Application by Net Zero Teesside Power Limited and Net Zero North Sea Storage Limited for the Net Zero Teesside Project
The Examining Authority's written questions and requests for information (ExQ1)
Issued on 19 May 2022.

ExQ1: 19 May 2022**Responses due by Deadline 2: 9 June 2022**

Drawing file: EN010103 / EN010103-001437-NZT DCO 4.6.1 Rev 1 - PCC Site Layout and Elevation Plan.pdf

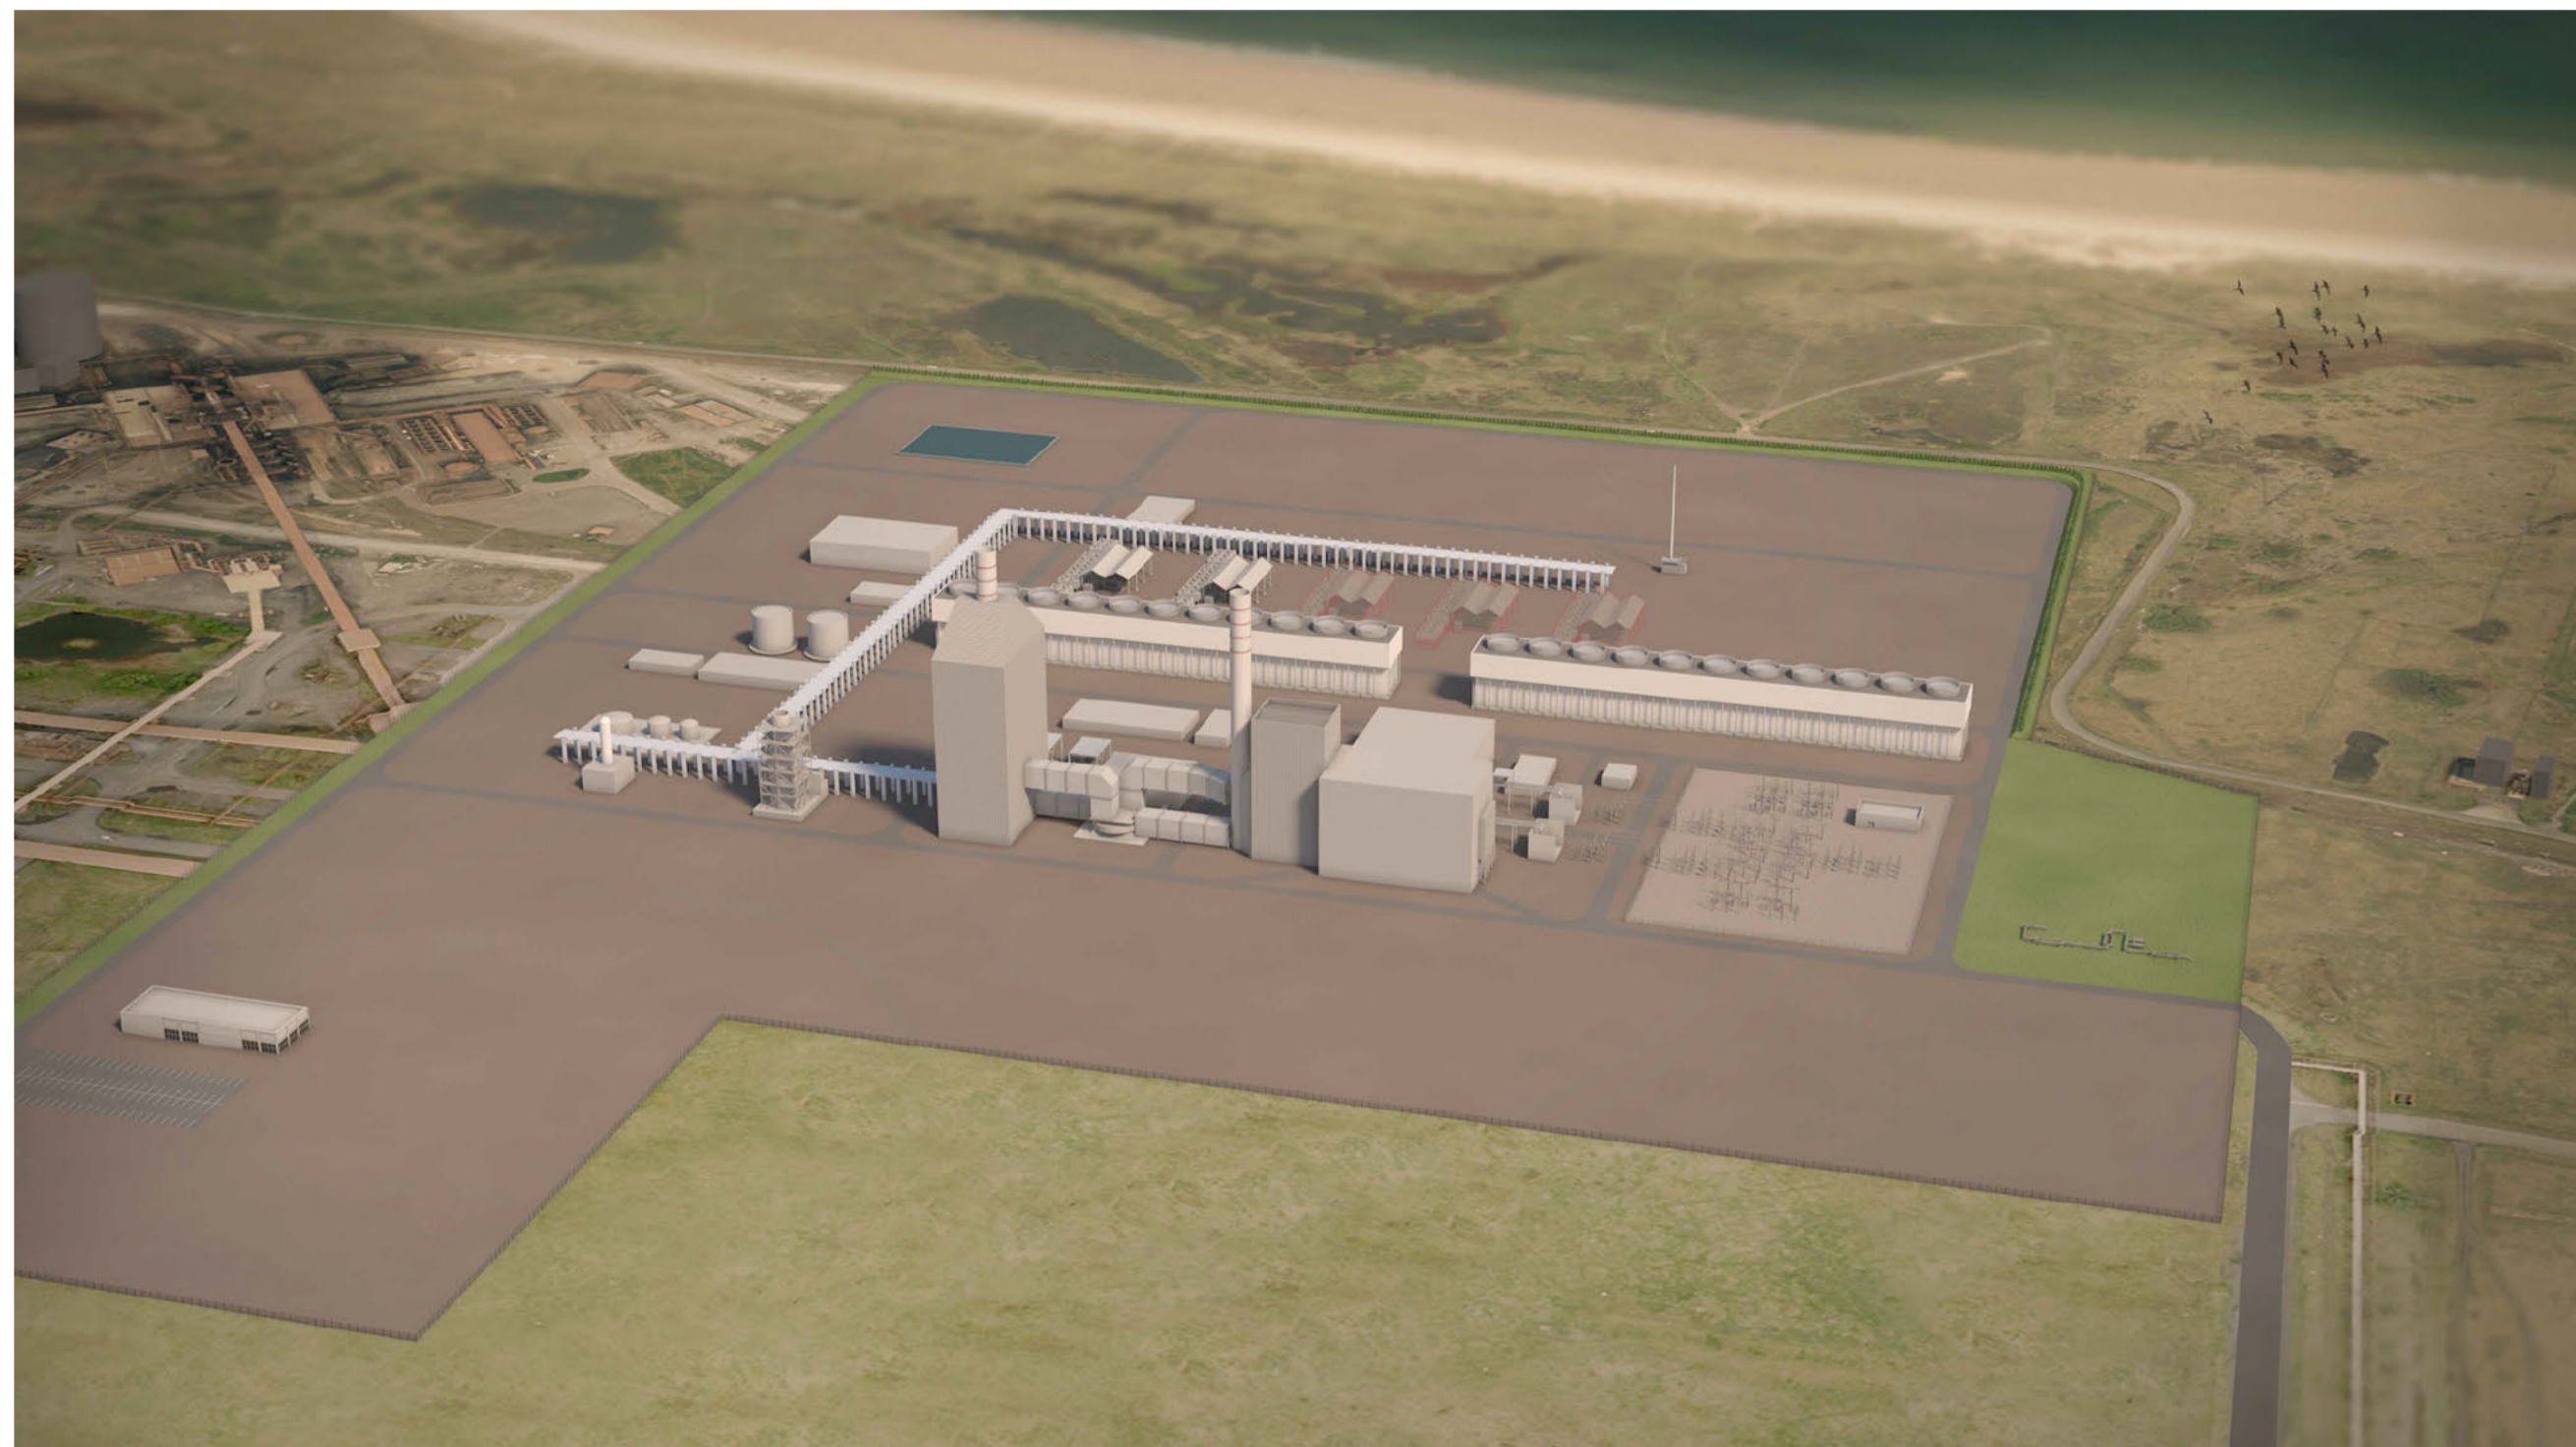
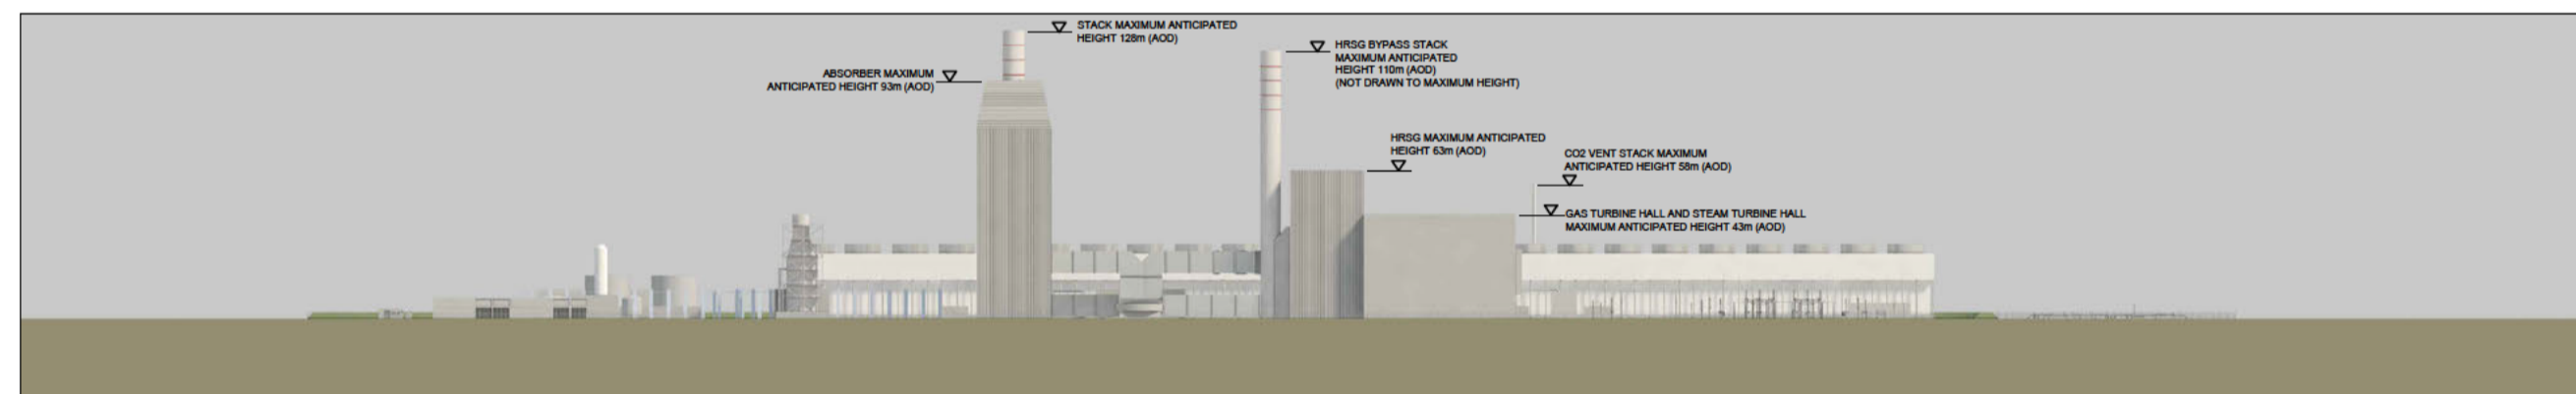
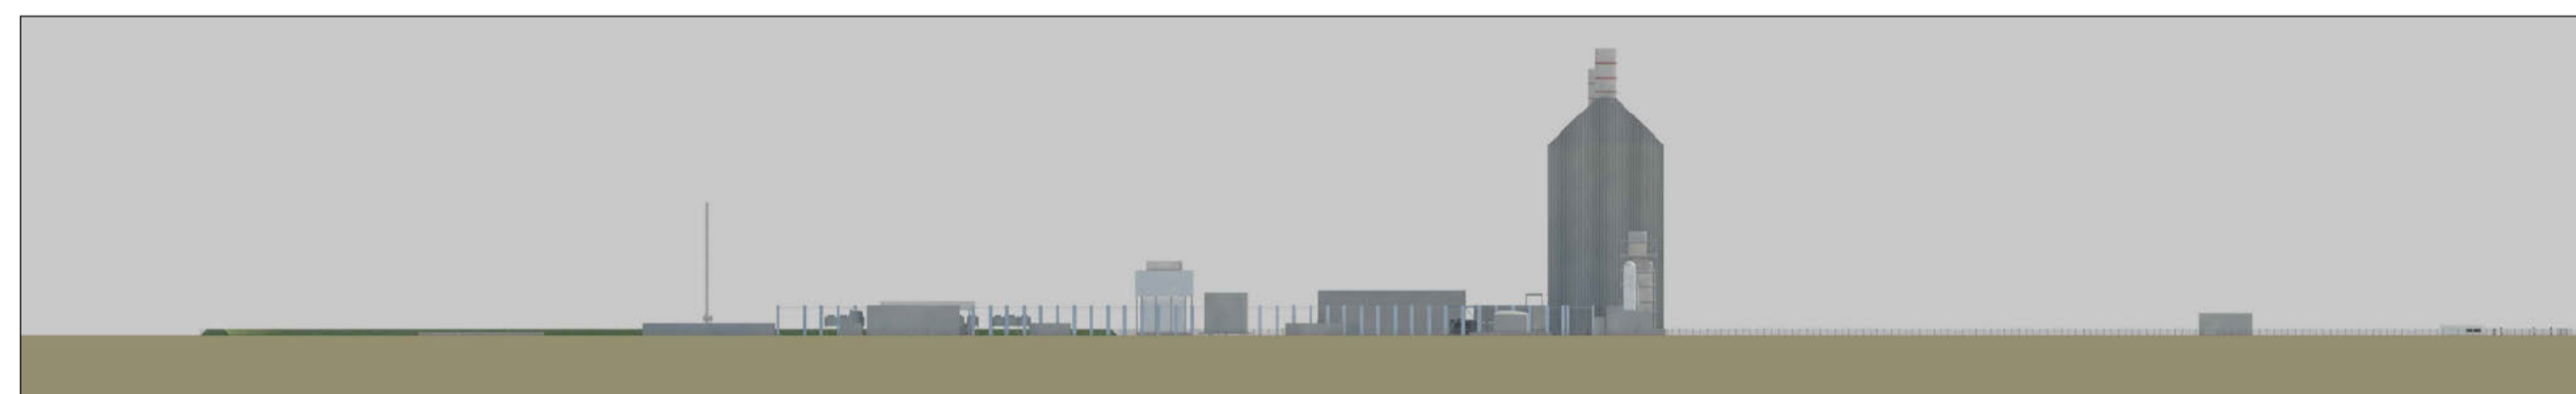
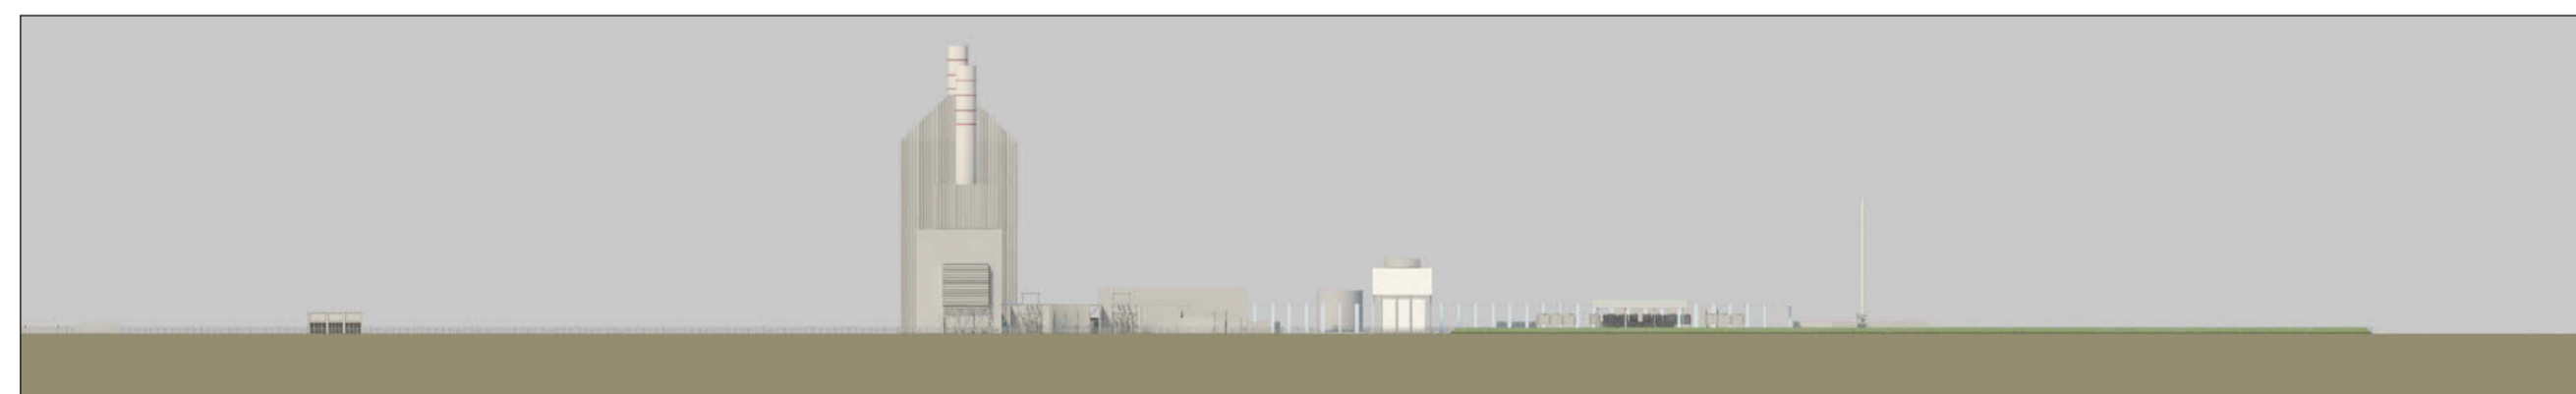
GEN.1.7	Applicants	<p>Can the Applicants confirm what the maximum width (inner diameter) of the main (absorber) stack is, as Schedule 15 of the dDCO states it is 6.5m but ES Chapter 8 describes the assessment using a parameter of 6.6m? If it is the former, does this have implications for the assessment of effects?</p> <p>Can the Applicants confirm the minimum width parameter for the main (absorber) stack that has been used in assessment in the ES and whether any sensitivity testing has been undertaken to understand the likely effects arising from the range of diameters?</p>
GEN.1.8	Applicants	<p>At various places within the application documents (including paragraph 5.2.3 of the ES [APP-087]) it is stated that the offshore works below Mean Low Water Springs (MLWS) are being progressed under separate consent.</p> <p>Should a new discharge pipeline need to be installed will the works extend below MLWS? If so, where has this been assessed in the ES?</p>
